OFFICIAL NOTIFICATION OF DECISION

Project# PR-2022-006841
Application#
SD-2023-00090 – PRELIMINARY/FINAL PLAT

For all or a portion of **LOTS 1, 2 & 5, BLOCK 3, SIGMA CHI ADDITION** zoned **R-MH**, located at **1801 MESA VISTA DR NE** between **BUENA VISTA ST NE** and **YALE BLVD NE** containing approximately **0.4672** acre(s). **(J-15)**

**Plat for  
Lot 1-A, Block 3  
Sigma Chi  
Being Comprised of  
Lots 1, 2 and 5, Block 3  
Sigma Chi  
City of Albuquerque  
Bernalillo County, New Mexico  
April 2023**

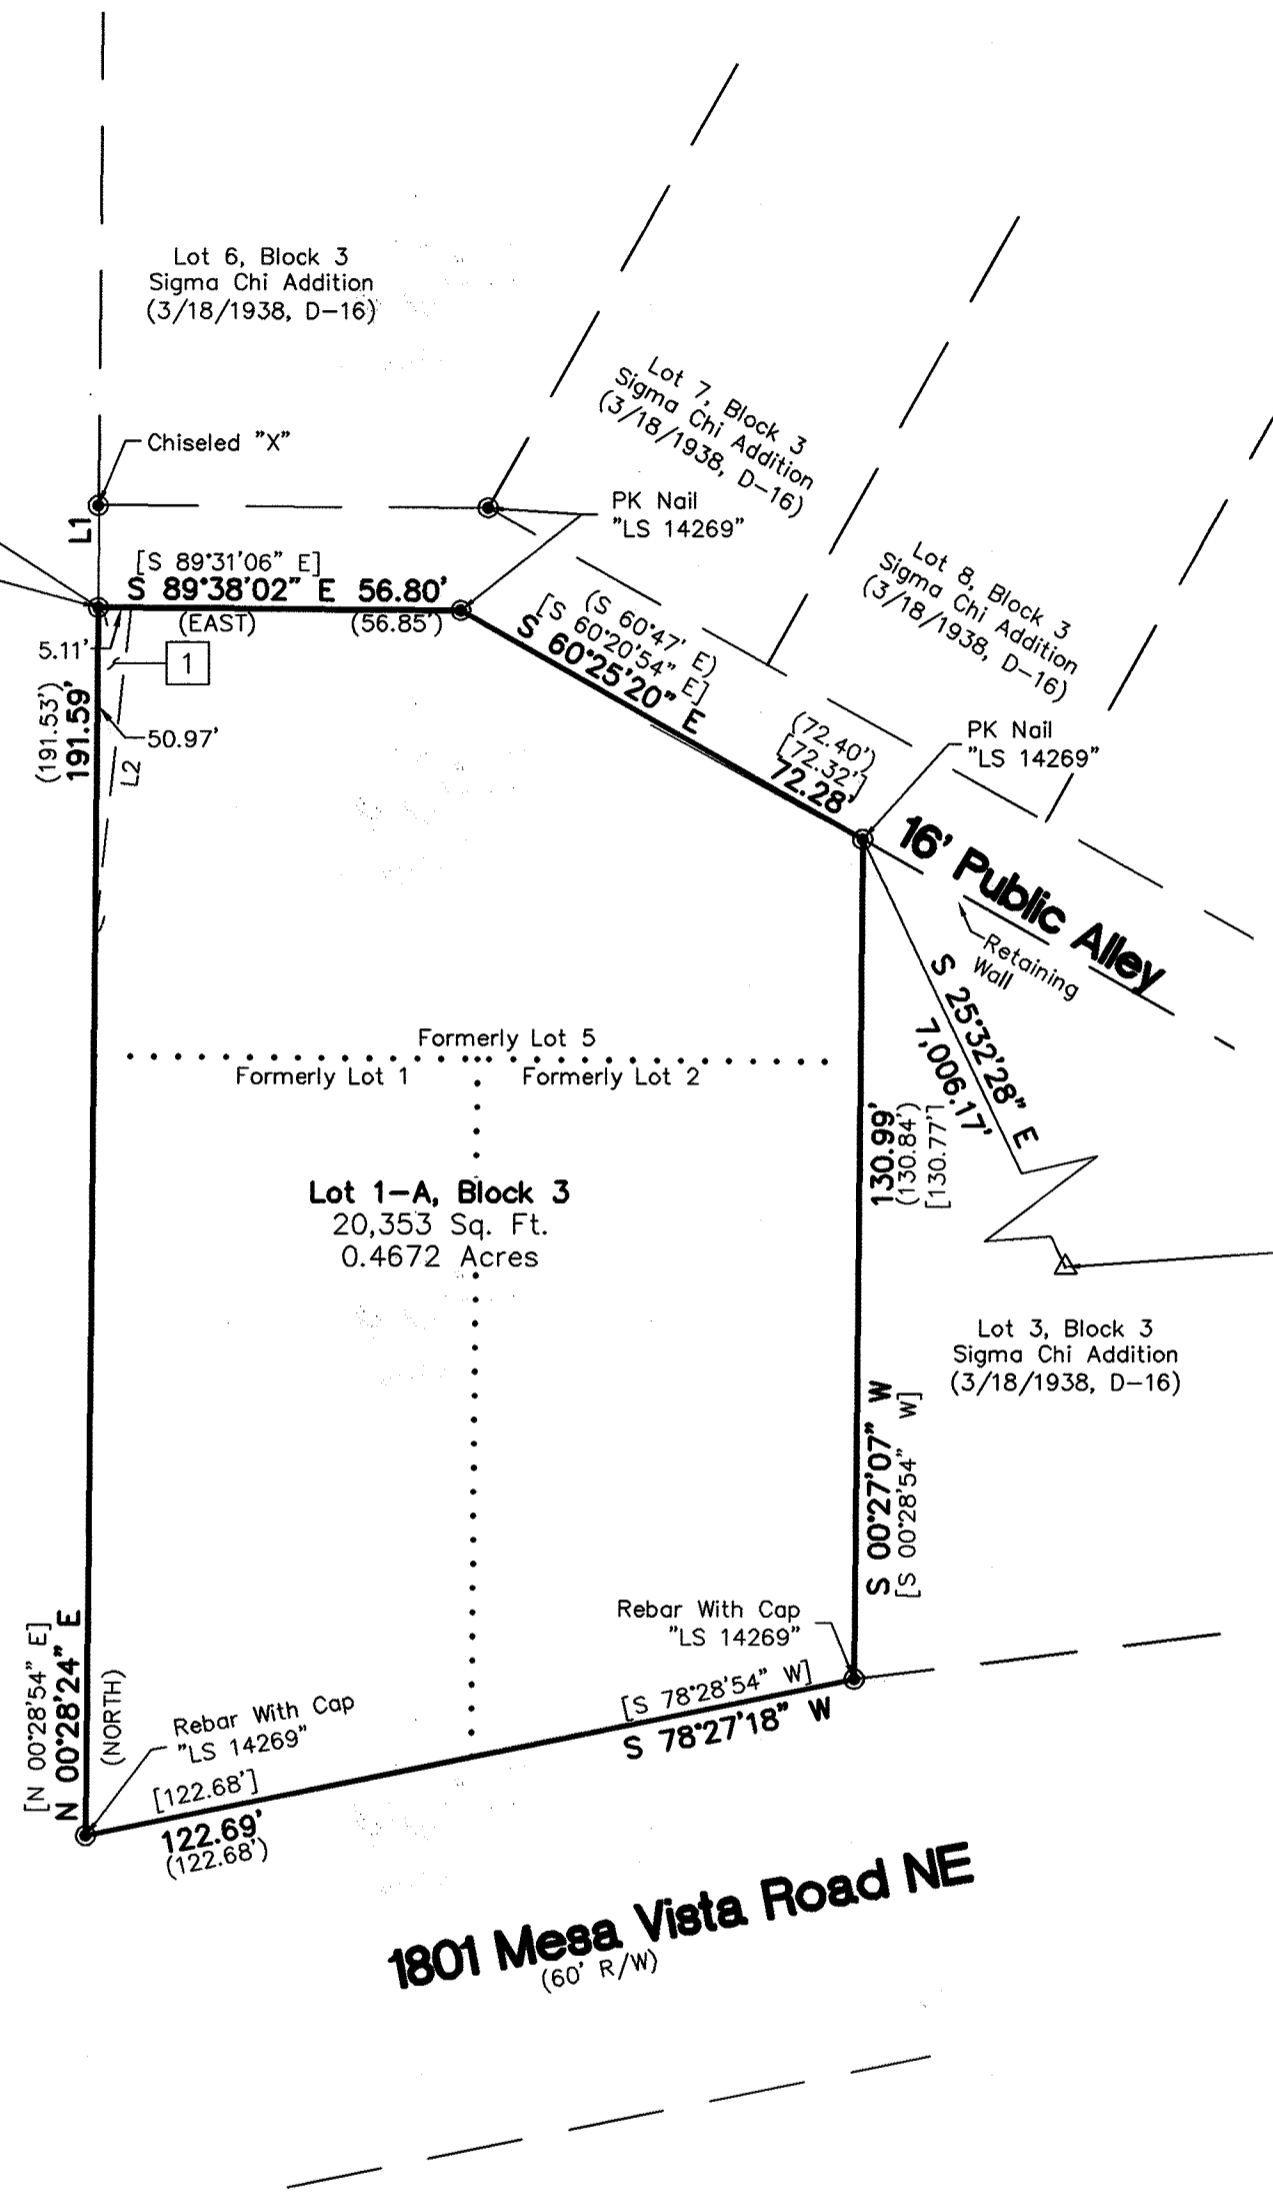
- a. Corners along the alley and Buena Vista, and Buena Vista and Mesa Vista shall be rounded or chamfered to avoid clear sight triangle.
- b. The application number must be added to the Plat.
- c. DXF file must be approved by AGIS and approval email submitted.
- d. The recorded IIA must be submitted
- e. Project and application numbers must be added to the Infrastructure List.
